Application Ref:	3/2021/0242	 Ribble Valley Borough Council <small>www.ribblevalley.gov.uk</small>
Date Inspected:	11/05/2021	
Officer:	AB	
DELEGATED ITEM FILE REPORT:		REFUSED

Development Description:	Outline application for up to 2 two storey residential dwellings (access and layout details applied for only)
Site Address/Location:	Land to rear of Glencroft Pendle Avenue Chatburn BB7 4AX

Figure 5 – Flood Zone 3 Extent in Topographical Survey

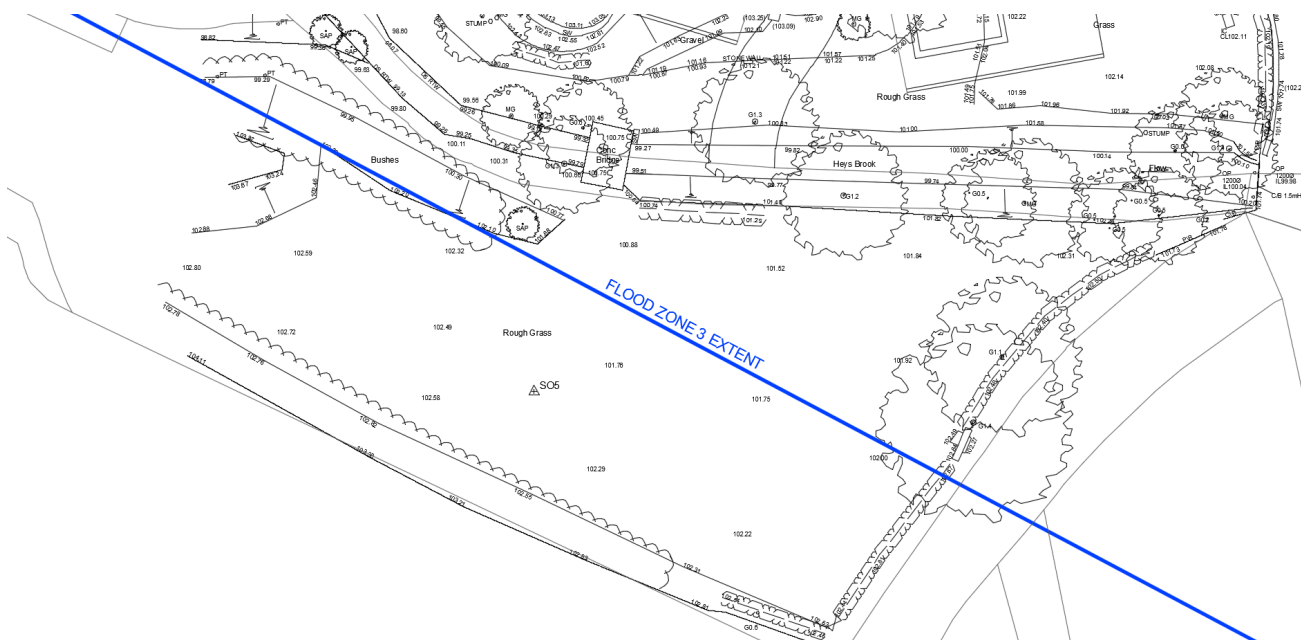
- *The flood extents do not follow the topography in this area, which demonstrates that the modelled flood extents at this location are not realistic. Due to the flood risk in this area and the proposed development being served by the proposed singular point of access, it is important that a more detailed assessment of flood risk is undertaken.*

- *The FRA states that the closest main river is the River Ribble, which is incorrect. Heys Brook which flows through the site is also a main river.*

Appendix E - Flood Mitigation Layout

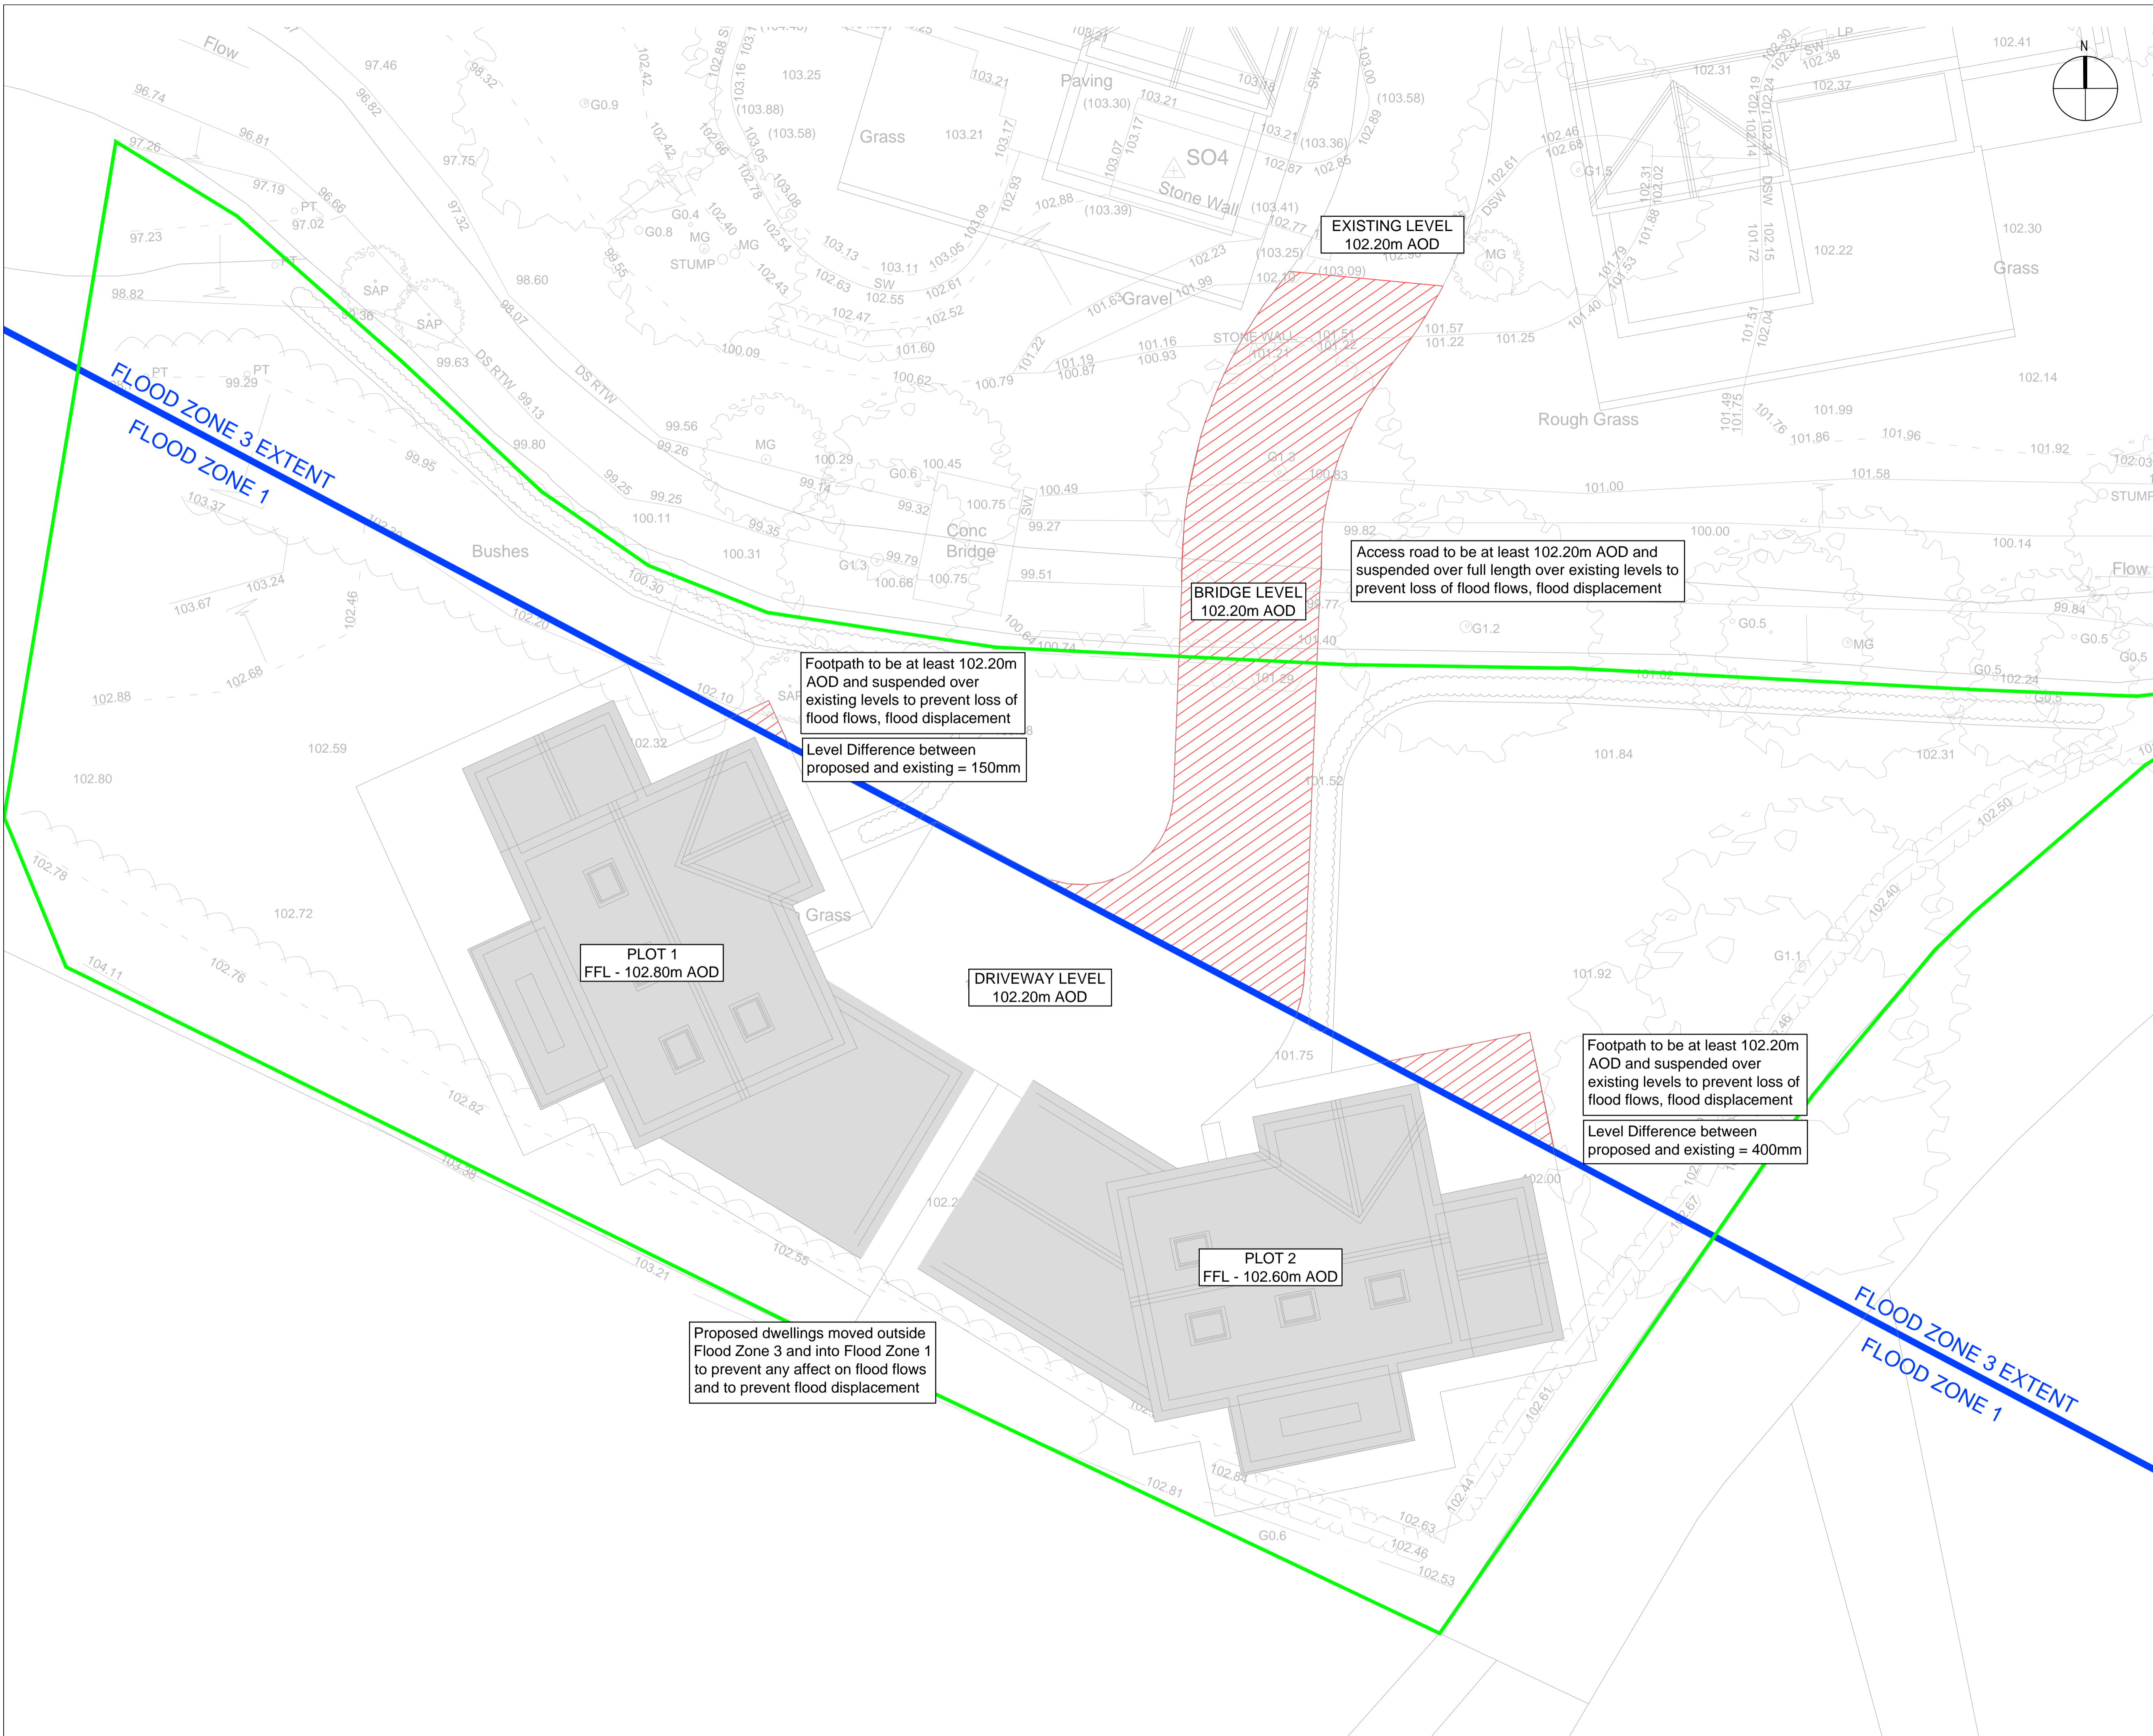
- *EA access to the main river, Heys Brook must be considered in more detail. A large amount of development appears to be proposed within 8m of the top of bank of Heys Brook which would impair the EA's access for maintenance and improvement works to the river. This includes fencing, suspended paths and drives and buildings. The EA requires that 8m from the top of the bank must remain development-free. It is unlikely that a permit for development within this area would be forthcoming.*

- *It is a concern that access and egress has not been adequately assessed to and from the site. It is likely that access to these properties will be cut off in a flood event potentially resulting in a risk to life. Currently, the proposal has outlined that there is a singular point of access and egress to the site which will cross the watercourse and its flood plain. Inadequate assessment of the access and egress to the site has been made and based on the information available at present, the properties are likely to remain cut-off and isolated in a flood event. In addition, there are a number of details which have not been provided which would further affect flood risk and access this includes; 1) Bridge and 2) Suspended driveway and footpaths.*

- *Neither a detailed bridge design nor an assessment of its impact on flood risk have been provided. Due to the broad scale nature of the available modelled information at this location, detailed modelling must be undertaken to demonstrate that the proposed bridge will not increase flood risk at the site and elsewhere in events up to the 1% AEP plus climate change. This is critical to confirm that the design of the bridge does not cause an increased risk of flooding and that flood free access is provided to the proposed dwellings.*

- *The proposed suspended driveway and footpath designs have not been provided and therefore very little assessment has been made in relation to the impact of the designs on flood risk. Suspended structures can reduce capacity within the flood plain and affect flood flows. The proposed designs must be provided and modelled to show that they will not adversely affect flood risk. In addition, the suspended structures will affect access to the watercourse as these are in close proximity to the site.*
